## **Application by Highways England for an Order Granting Development Consent for the A38 Derby Junctions Scheme The Examining Authority's further written questions dated 5 May 2020**

The following table sets out the Examining Authority's (ExA's) further written questions. The further written questions are directed to specified parties, but responses will also be accepted from other Interested Parties.

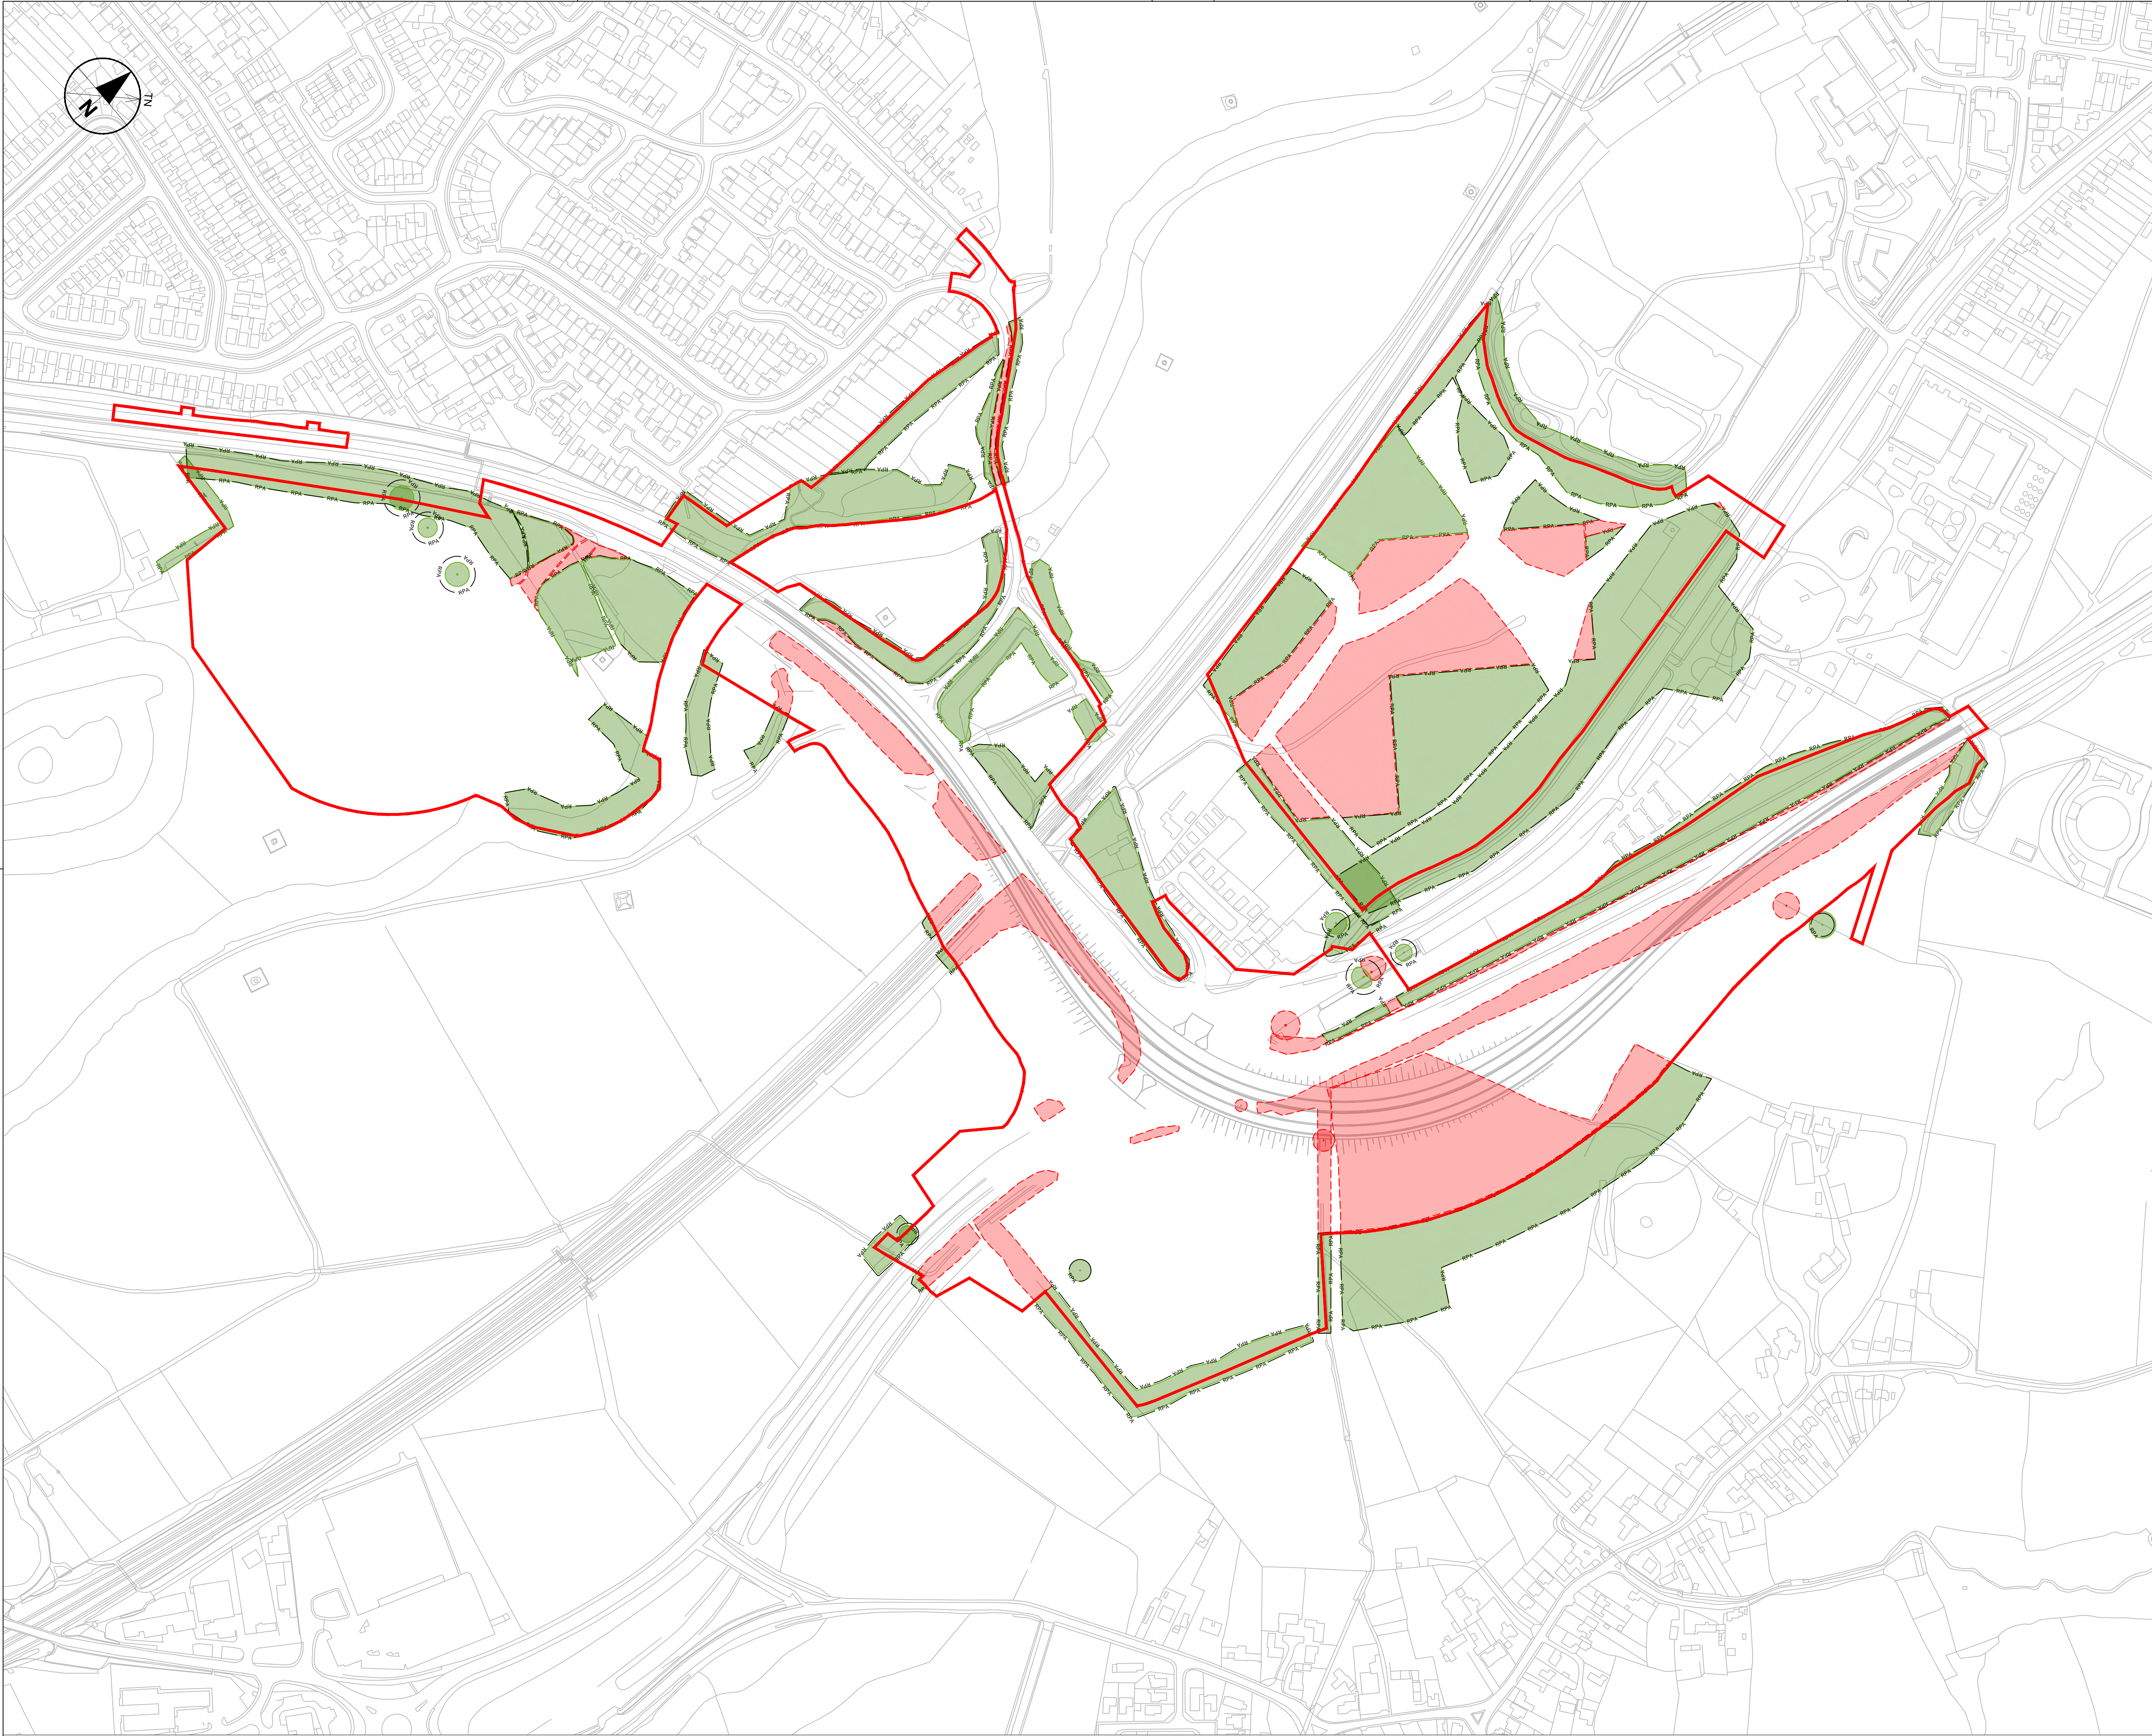
7.1.	Applicant	The effect of the proposed development on veteran tree T358	<p>a) DCiC has suggested that it may be possible to retain the veteran tree with a reduced canopy and root protection area. Please comment on whether this can be achieved by:</p> <ul style="list-style-type: none"> <li>• moving the carriageway further west within the existing limits of deviation;</li> <li>• introducing protection measures for the root protection area, including working methods and avoiding impacts from utility services; and</li> <li>• undertaking necessary works to the tree canopy.</li> </ul> <p>b) Please identify how any of these specific measures can be secured in the OEMP [REP10-002], as appropriate.</p>
